**Re: Sandia Laboratory Federal Credit Union at 5700 St Joseph's Dr. NW  
Erosion and Sediment Control Plan  
Engineer's Stamp Date 1/4/24 (G11E067B)**

Based upon the information provided in your submittal received 1/11/2024, the above-referenced ESC Plan cannot be approved for Grading Permit or Building Permit until the following comments are addressed.

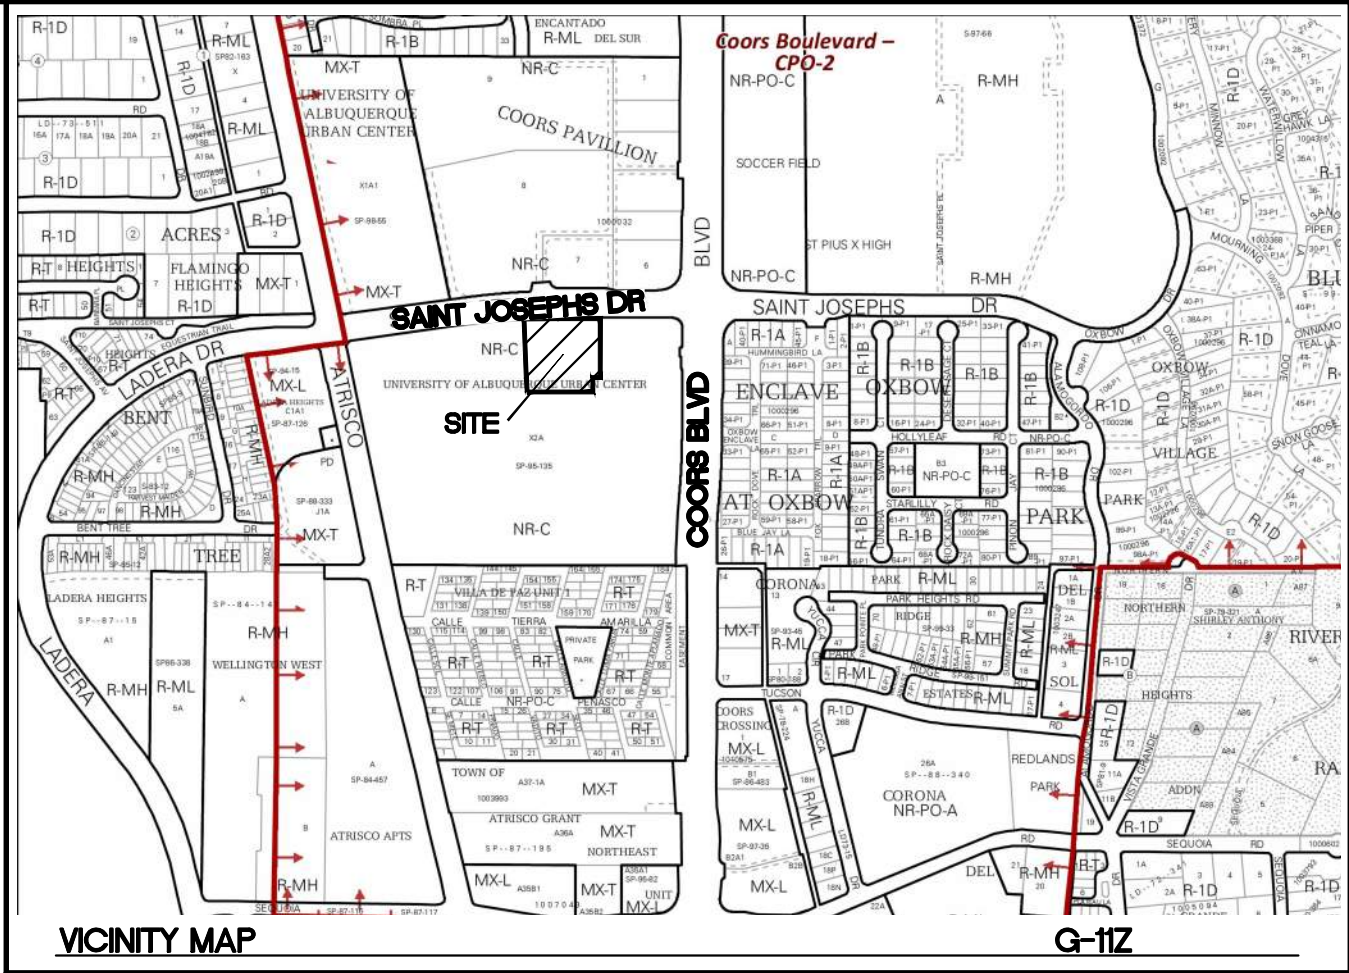
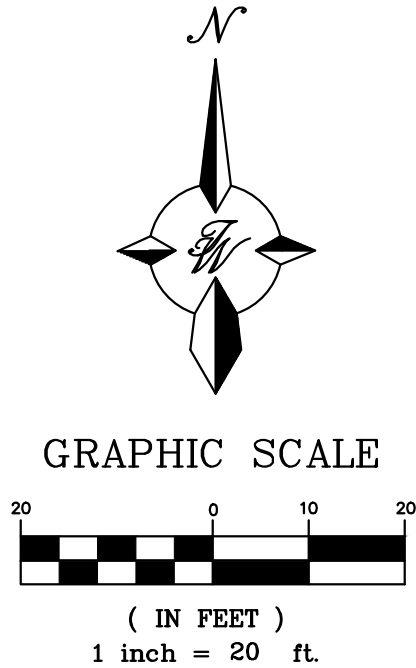
1. The owner information shown on the Information Sheet, "Sandia Laboratory Federal Credit Union leased from Red Shamrock 12, LLC", implies that both entities qualify as operators, but the only NOI submitted is for Sandia Laboratory Federal Credit Union. An additional NOI for Red Shamrock 12, LLC is required per CGP 1.1.1. Oxbow Center is Common Plan of Development or Sale as defined in Appendix A of the CGP, and Sandia Labs FCU's site is part of the common plan. You must identify all other operators who will be engaged in construction activities at the site, and the areas of the site over which each operator has control per CGP 7.2.1. The ESC Plan(s) must The terms of the lease are unclear and these two operators may have overlapping areas of control at different times during the development of this site. Please provide a copy of the lease to help clarify the how the areas of control will vary over time. Also identify if these two operators will have separate SWPPPs or if they will share one SWPPP.

- b. 3,600 cubic feet per acre drained.
4. The City Standard ESC Notes are outdated. Please use the current City Standard ESC Notes attached.
5. Update the engineer's stamp date each time the plan is changed.

OUTLET (PERSPECTIVE)
TEMPORARY SEDIMENT TRAP (ST)
N.T.S.

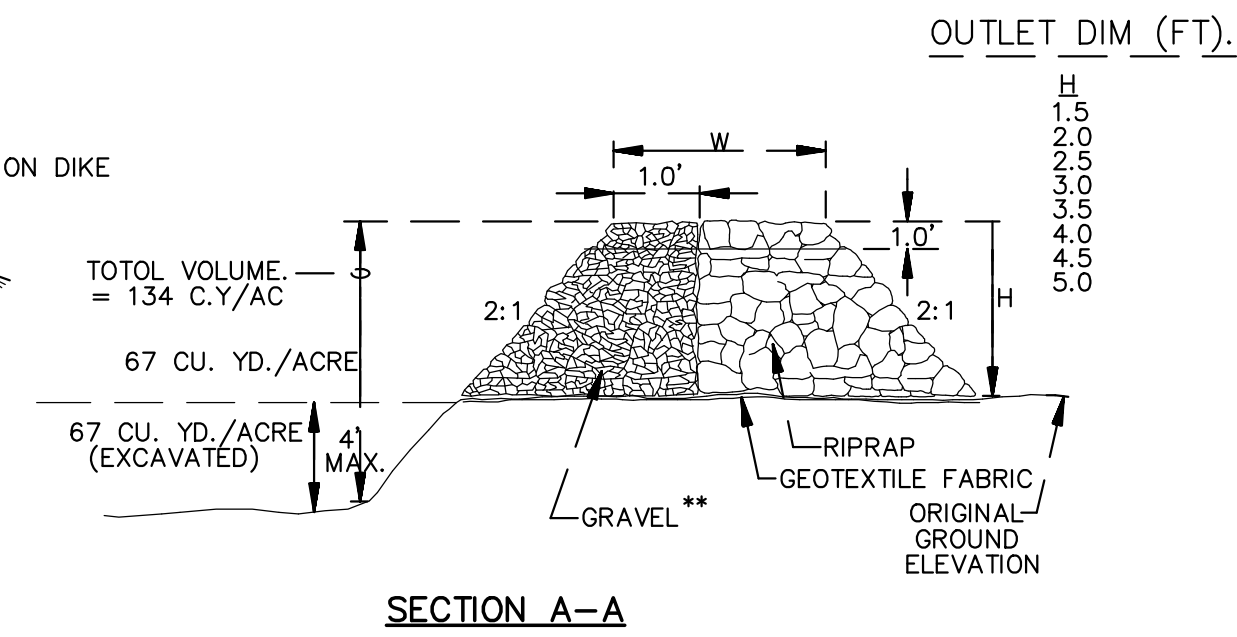
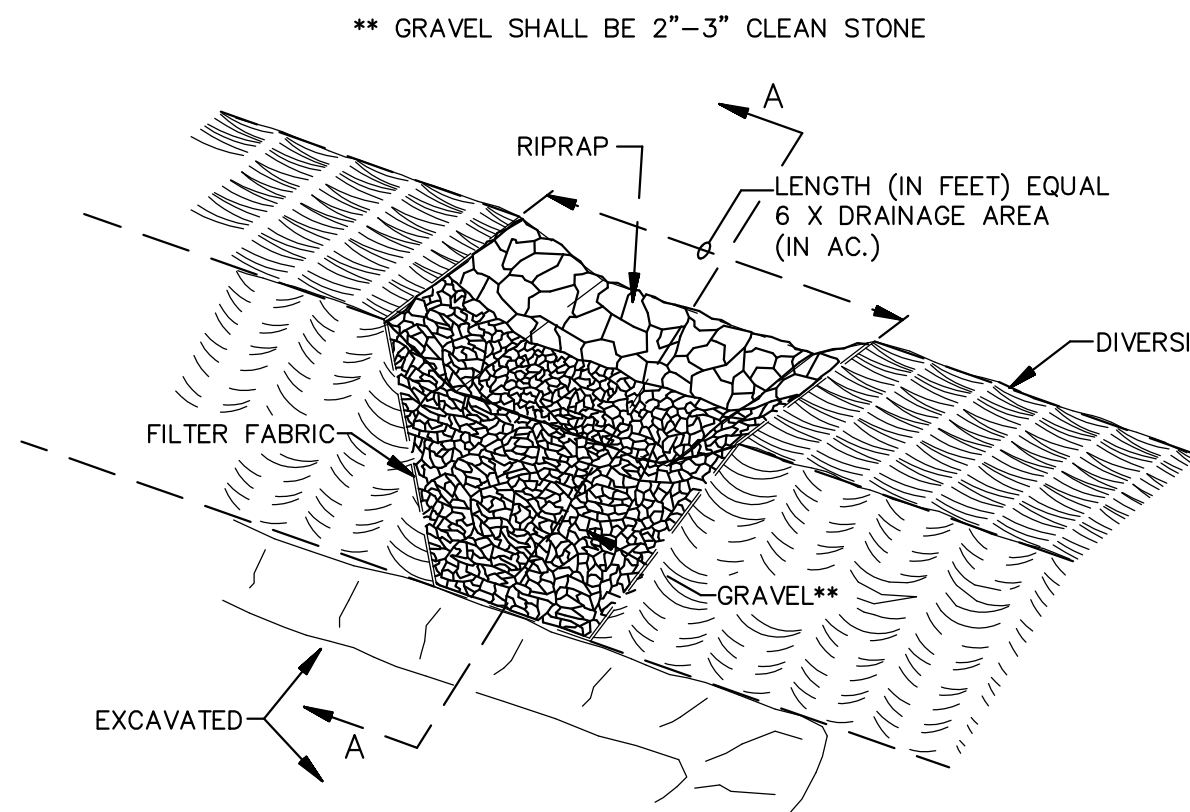
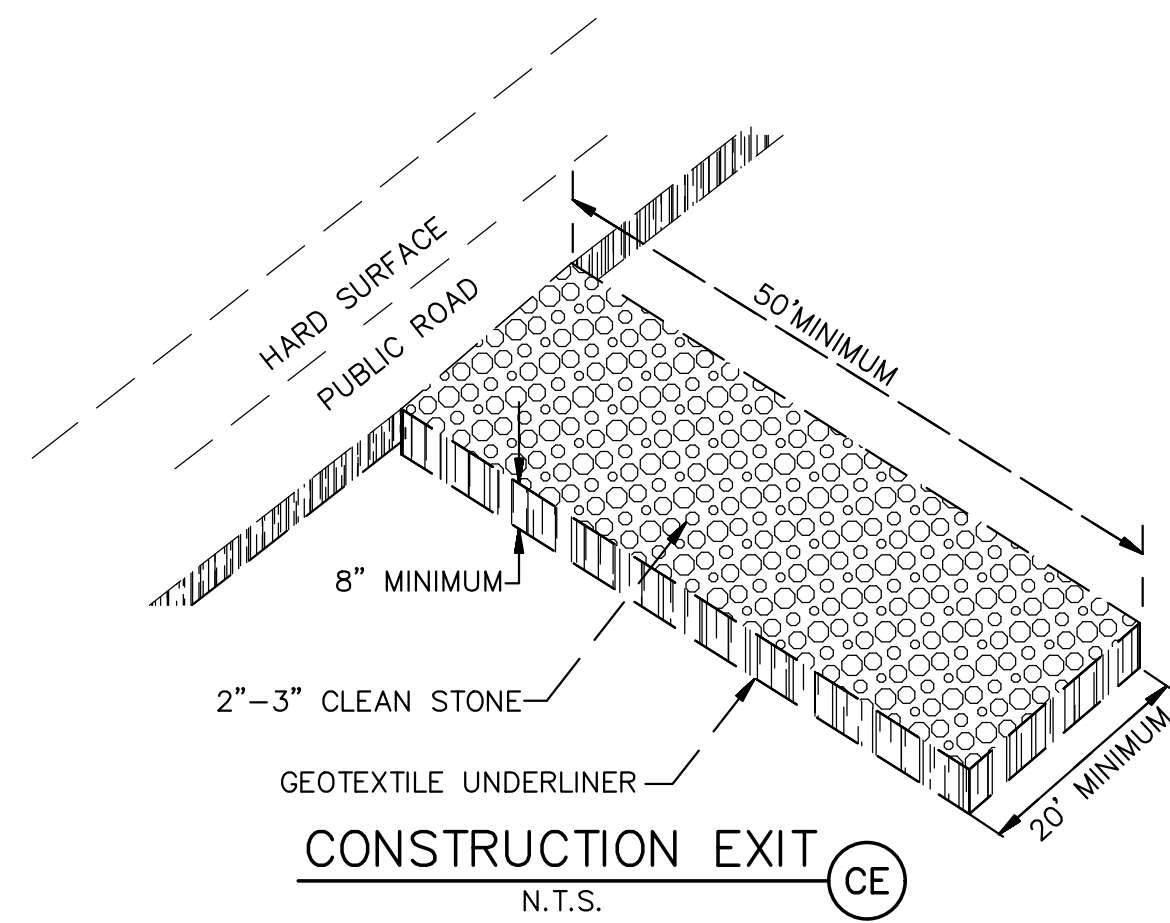
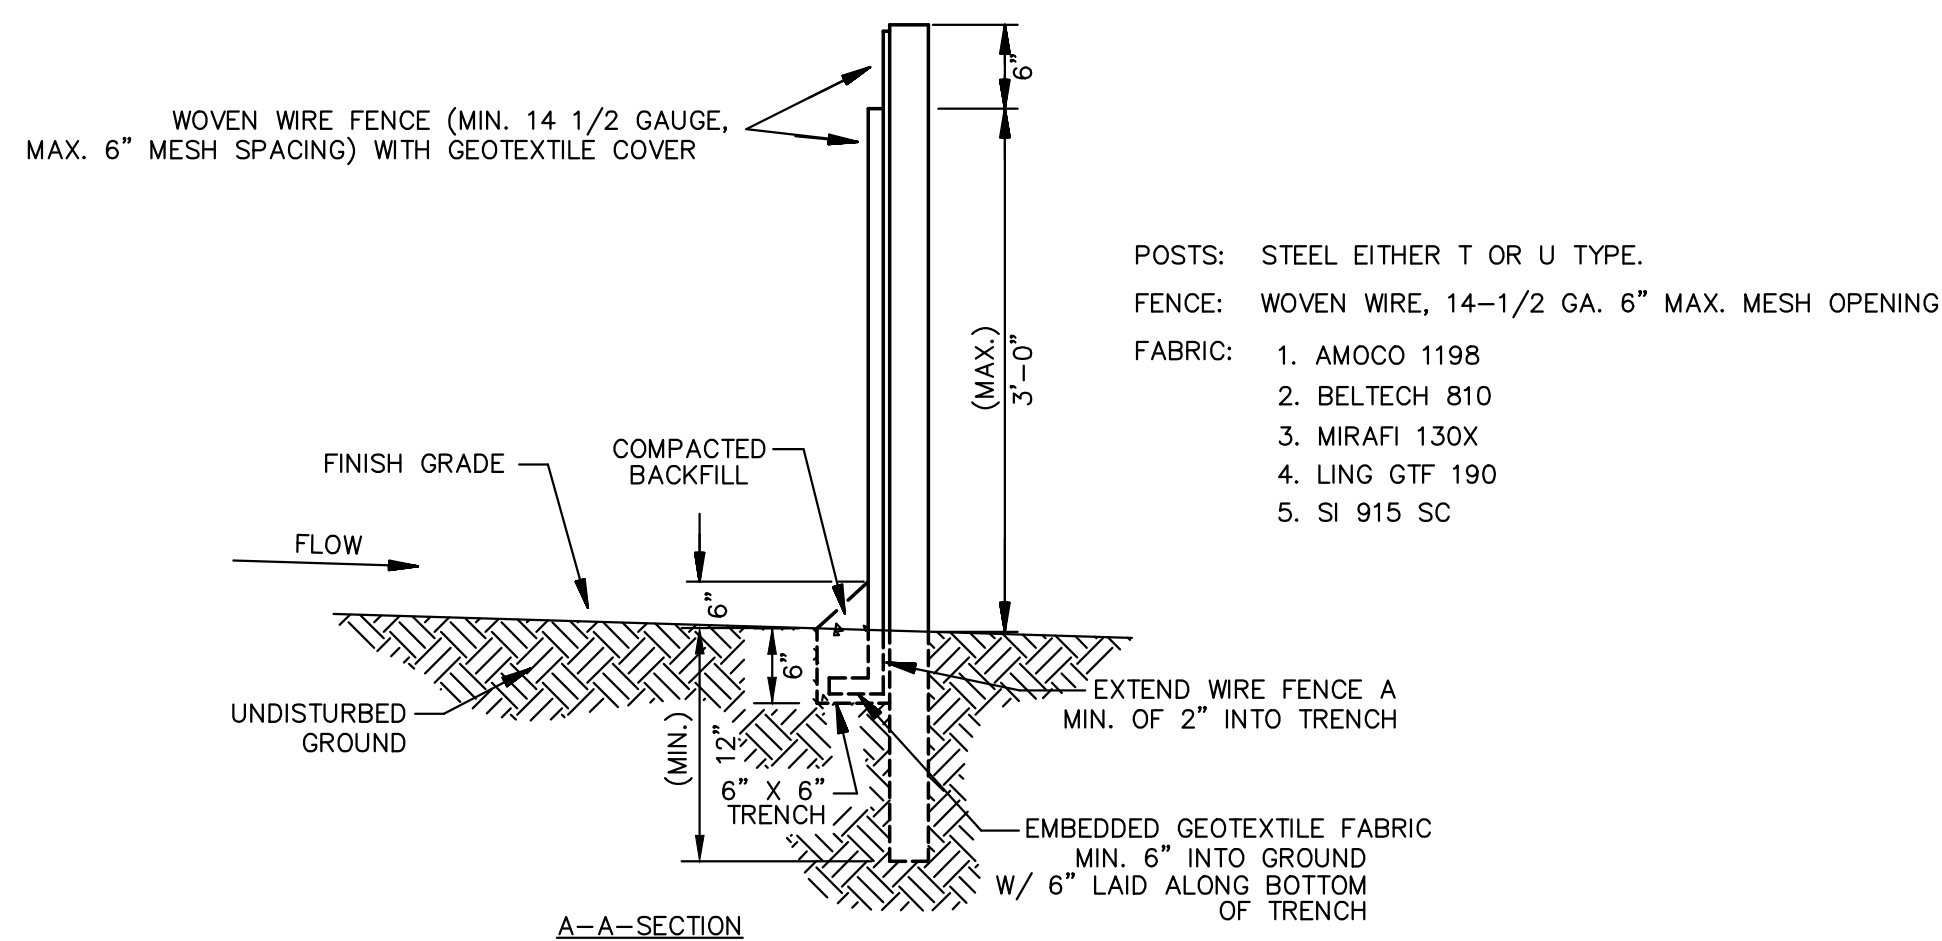
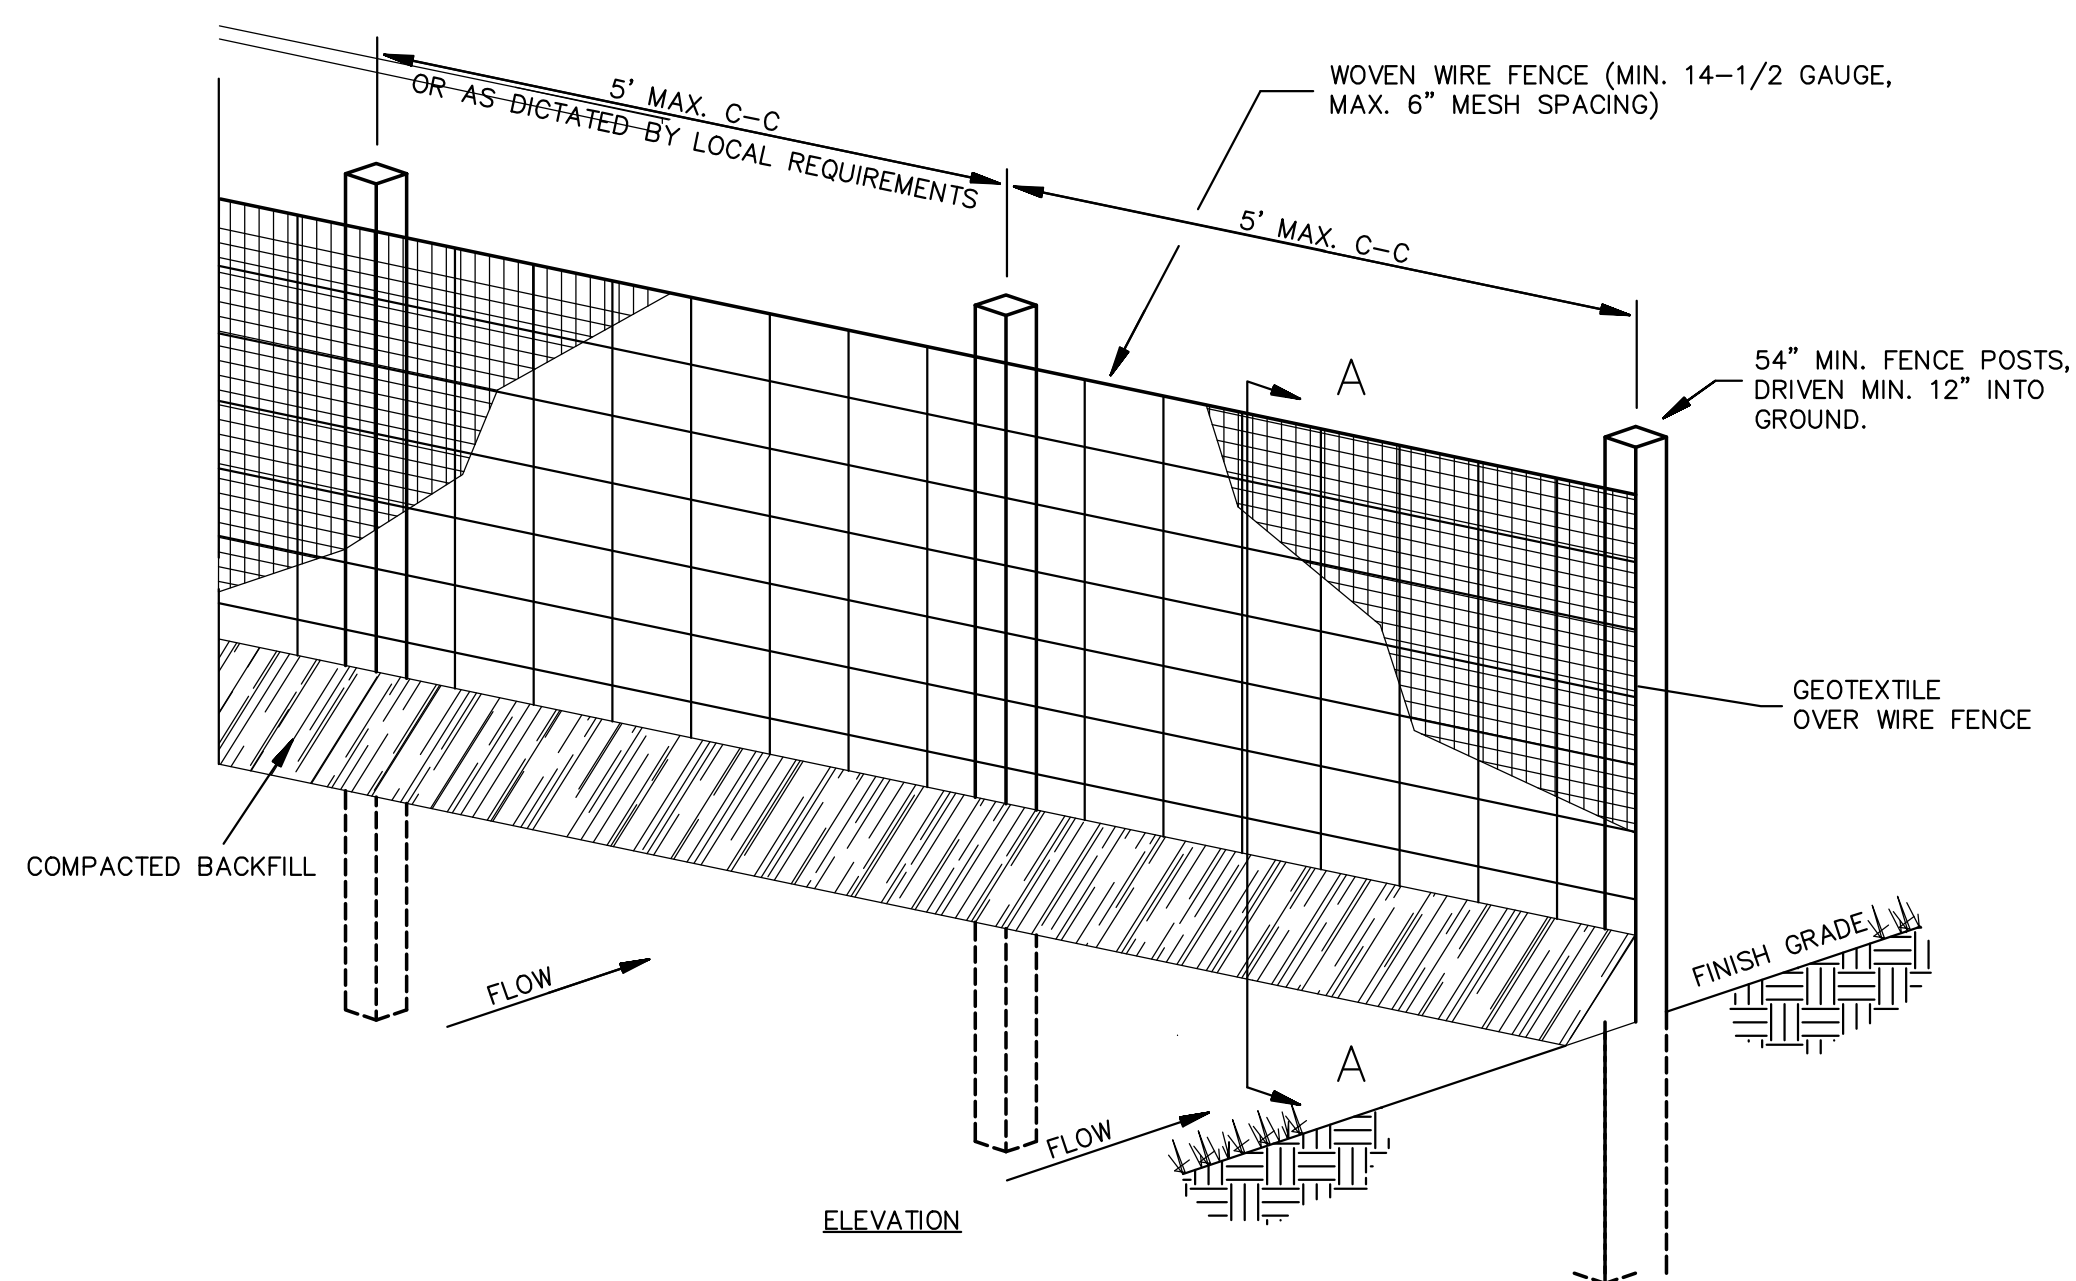
3. Provide calculations for the Sediment Trap design showing compliance with CGP Part 2.2.12.c which requires storage for either:
  - a. The calculated volume of runoff from a 2-year, 24-hour storm; or
